RESPONSE TO PLANNING COMMENTS INCLUDING CALCULATIONS – Rev. D

SIMPLY UK

HOOK ROAD, PAGHAM

CS&P REF: 9418

TYPICAL INSPECTION CHAMBER DETAIL

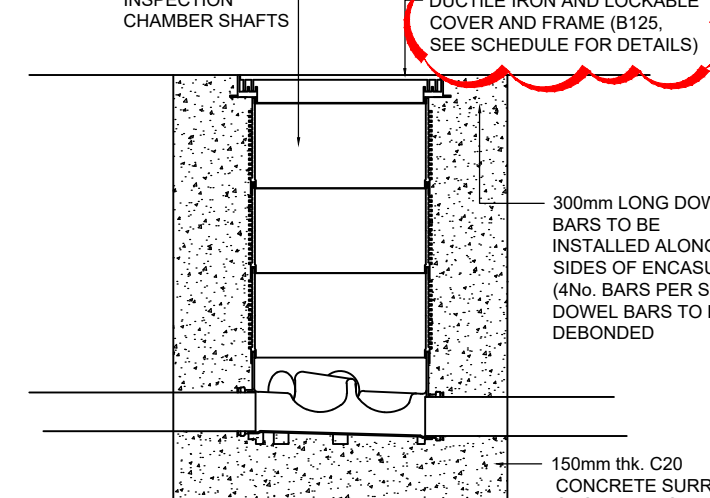
- p) The Typical inspection chamber detail appears to show a light duty cover which contradicts the manhole schedule.

We have updated our drawings in Appendix F. Inspection chamber covers are shown on the Manhole Schedules/C003.

TYPICAL MANHOLE DETAIL - 3m DEPTH - TYPE B

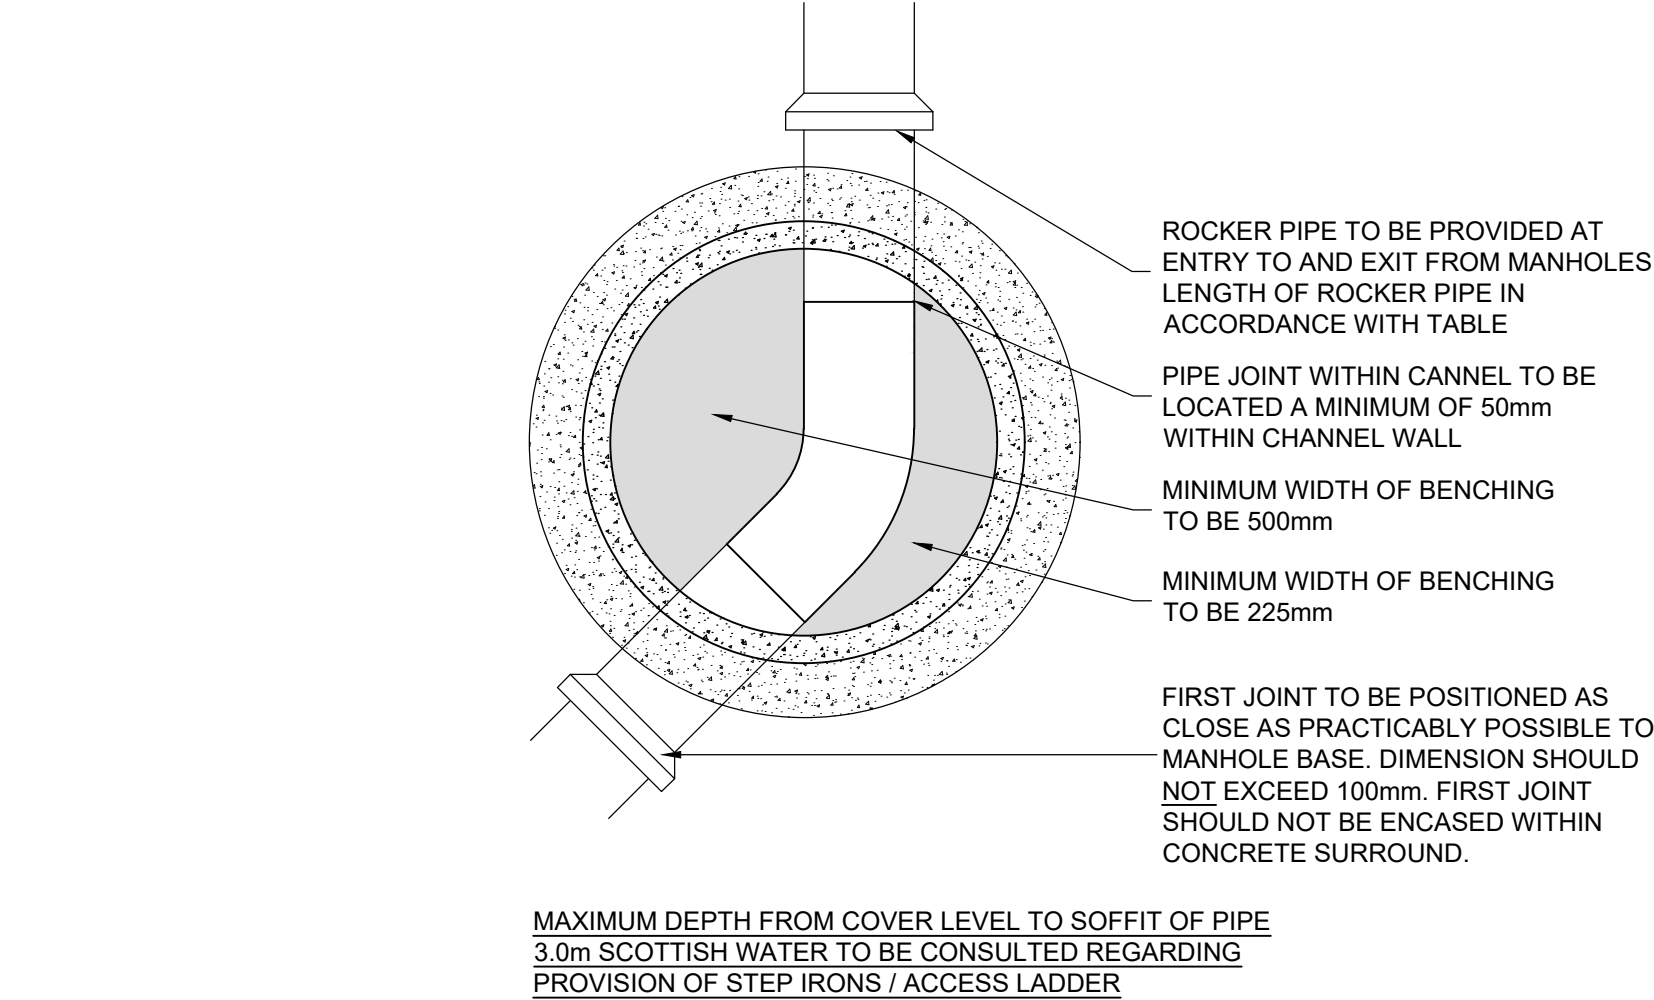
- m) The typical manhole detail states a range of diameters that are dependant on depth and contradict the manhole schedule.

- n) Demonstrate that sufficient working space will be available under the cover slab in the 1200mm dia manholes (usually 900mm is required from top of benching to underside of cover slab).

- o) The typical manhole detail shows a grade D400 cover which contradicts the manhole schedule.

These are standard details. We have updated our drawings in Appendix F.

We have updated our drawings in Appendix F. Manhole Details show rungs at 300mm centres. There is greater than 1m height (5no). The note also indicates step irons not required where <1m.

We have updated our drawings in Appendix F. All covers are noted as B125 covers.

TYPICAL PERMEABLE PAVING DETAIL

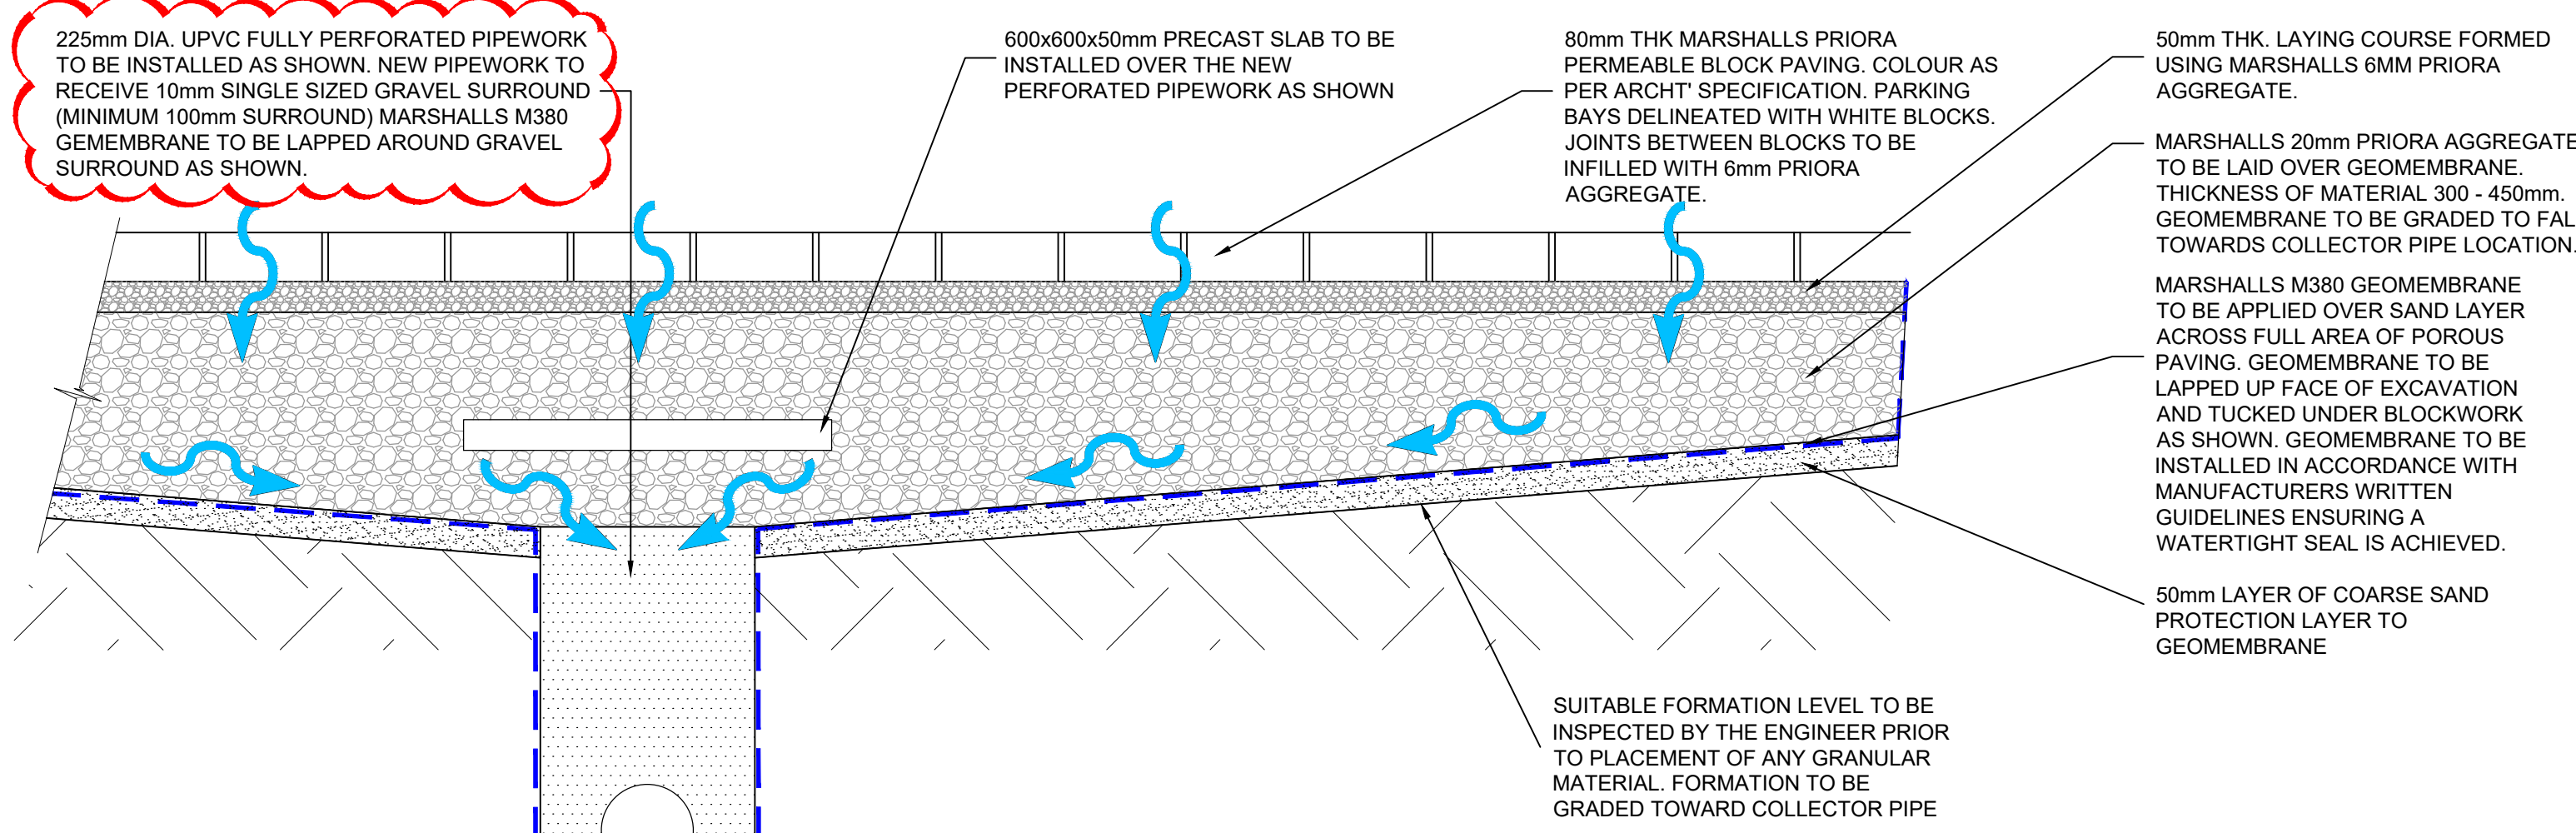
- j) The permeable paving detail shows a 150mm perforated pipe, the calculations and plan show a 225mm perforated pipe.

This has no impact on the drainage design. We have updated our drawings in Appendix F.

TYPICAL SECTION ALONG ATTENUATION SYSTEM (REFER TO DRAWING C016)

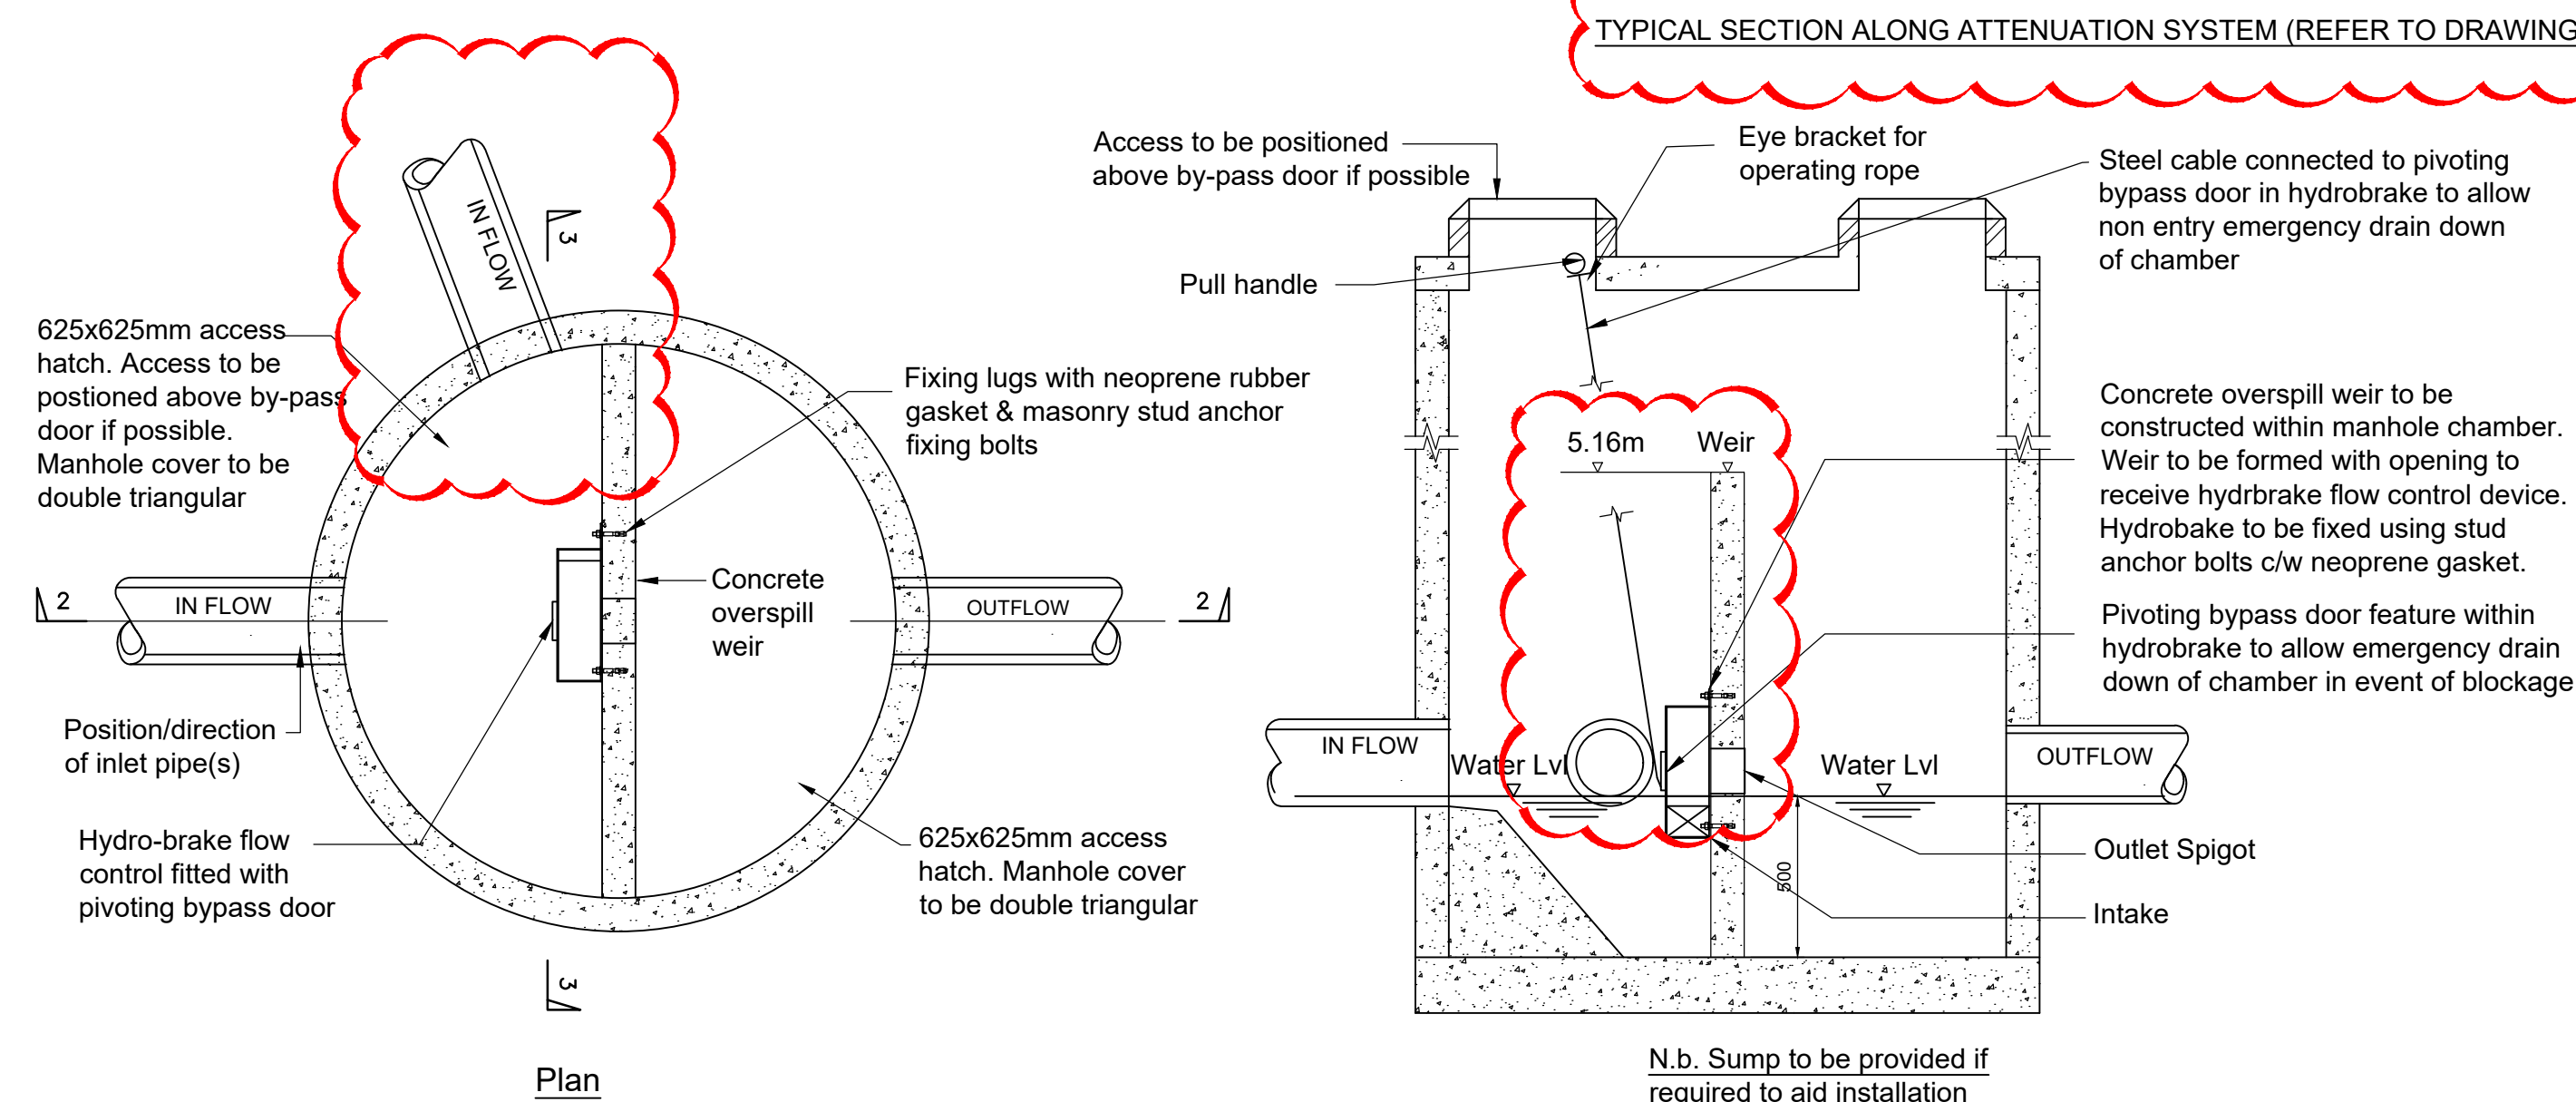
- a) The tank detail shows a manifold arrangement for the tank connections, the plan shows a single pipe. A.

- e) The tank detail suggest that pipes run through it at base level, this is not shown on the plan.

These details were provided in previous Rev. C. calculations. We have updated our drawings in Appendix F.

We have updated our drawings in Appendix F.

Dual entry weir wall control manhole detail as SW MH 02.04 Not to Scale

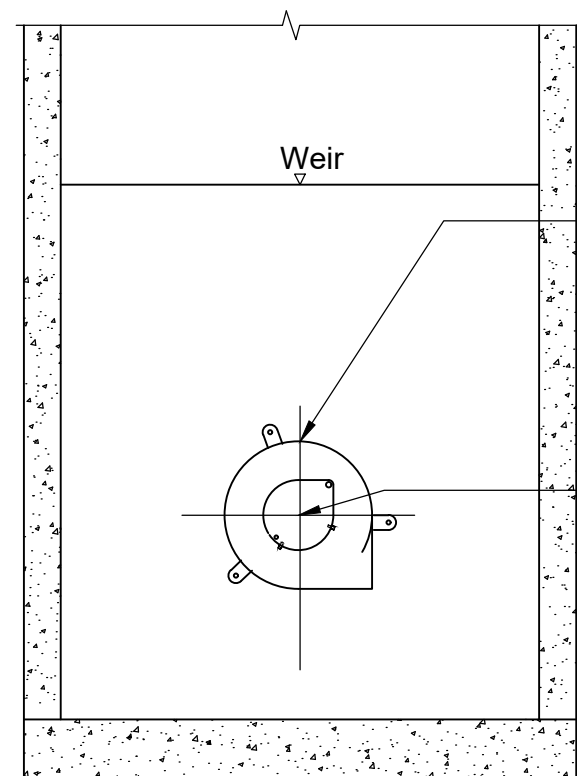
- k) The flow control chamber detail does not appear to reflect what is shown on the plan.

- l) Provide details of how the flow control device will be protected from blockage given that its pass through is less than the recommended 75mm.

This was answered in previous Calculations. We have updated our drawings in Appendix F.

We have updated our drawings in Appendix F. As shown on details – steel cable connected to pivoting bypass door for blockages as shown on C003 drawing.

GRAF ECOBLOC MAXX STORAGE SYSTEM (ST1)
(21.6x2.4x0.61m - 30.04m³)

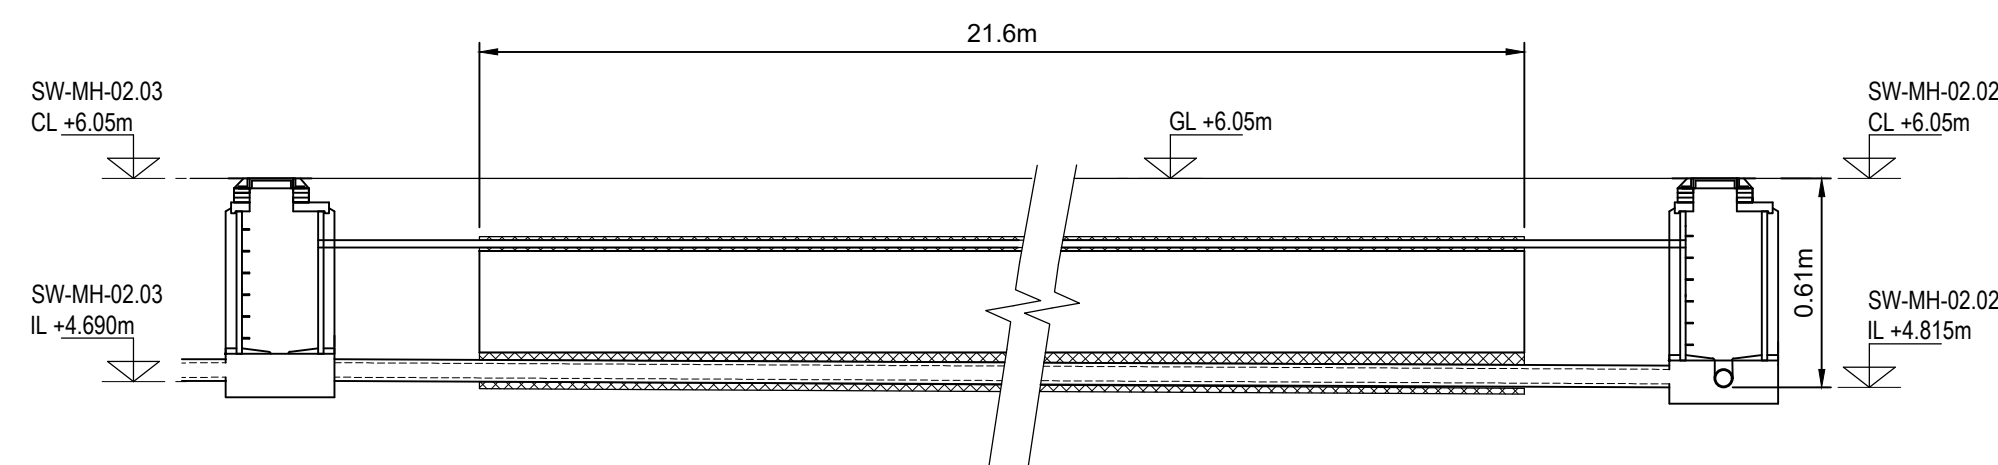
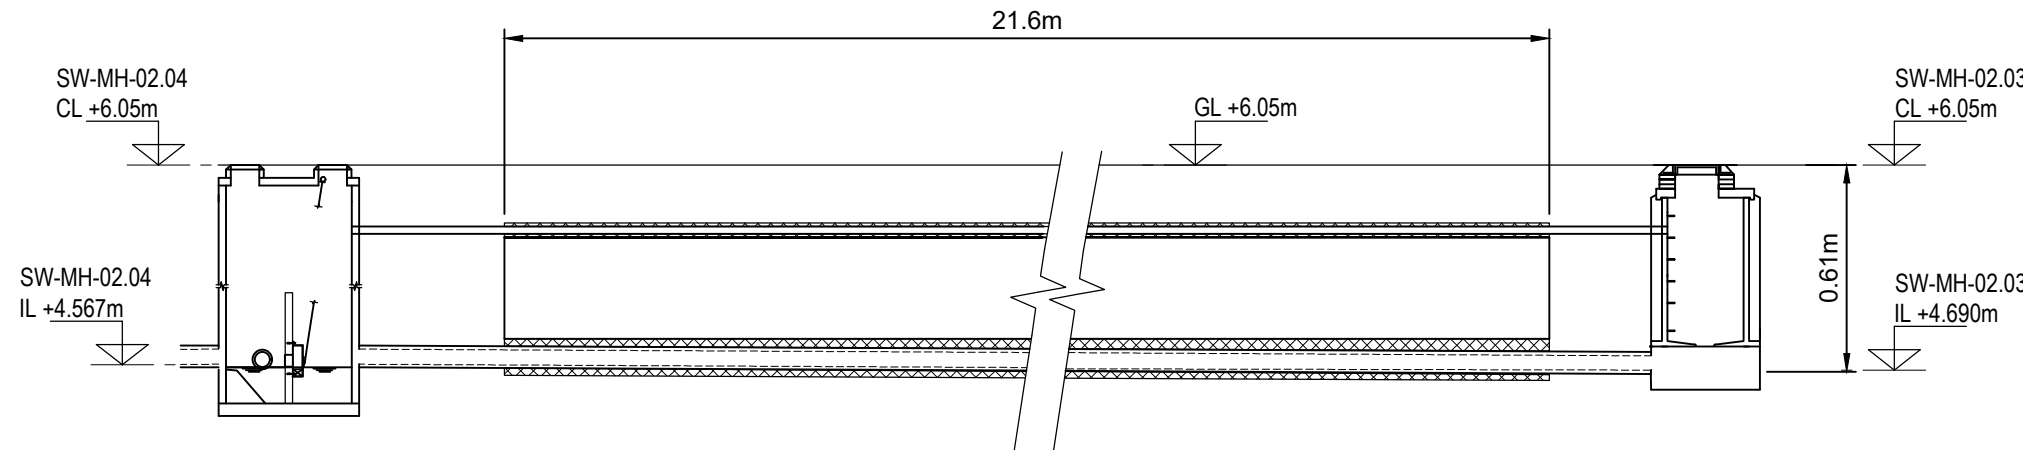
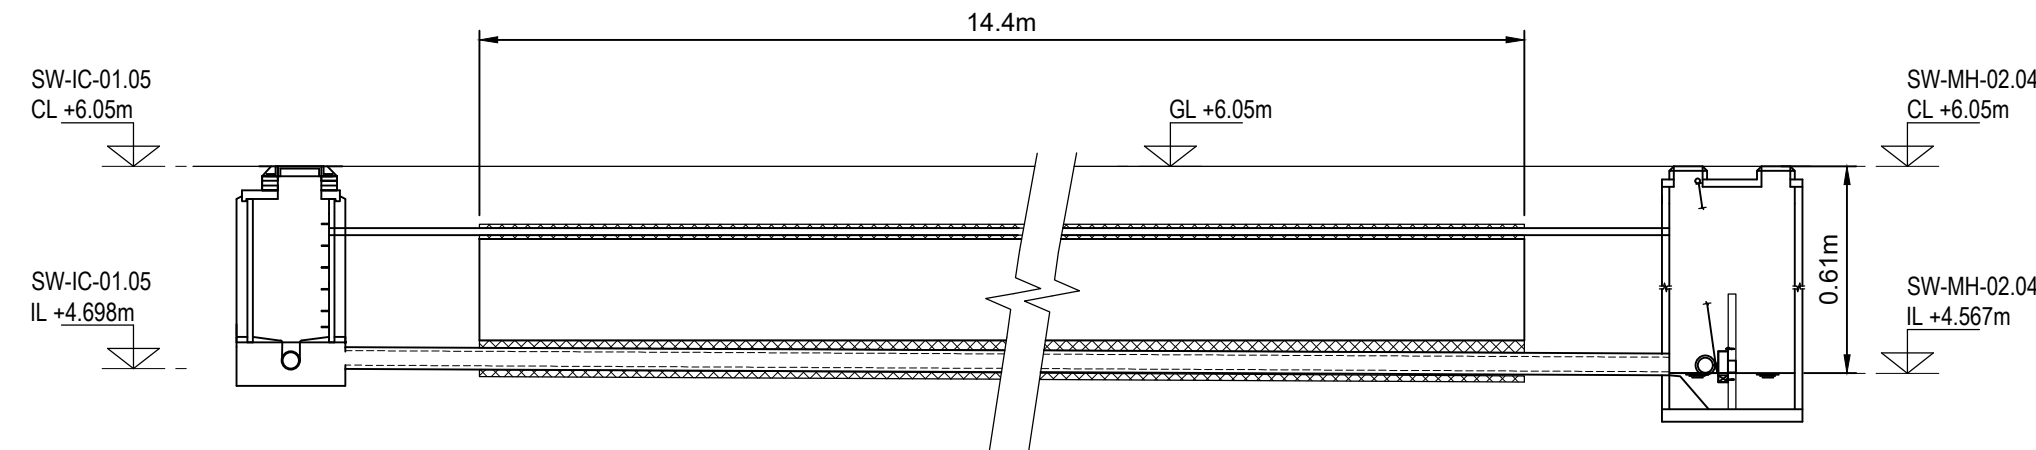
- e) Tank SW1 appears to be oversized in the calculations. The drawing states $21.6 \times 3.6 = 77.76\text{m}^2$. The calculations use an area of 82.1m^2 .

- c) The volume stated for tank ST2 is not consistent with the plan.

- h) The tank detail specifies a plan size that is not consistent with the drainage plan. Rev. C Calculations.

*We have revised the Calculations Plan drawing in conjunction with Drainage Drawing. Tank ST2 notes 21.6m long * 3.6m wide. We have revised these calculations to show 77.76 m2 area. See revised calculations in Appendix B.*

These details were provided in previous Rev. C. calculations. We have updated our drawings in Appendix F.

We have updated our drawings in Appendix F.
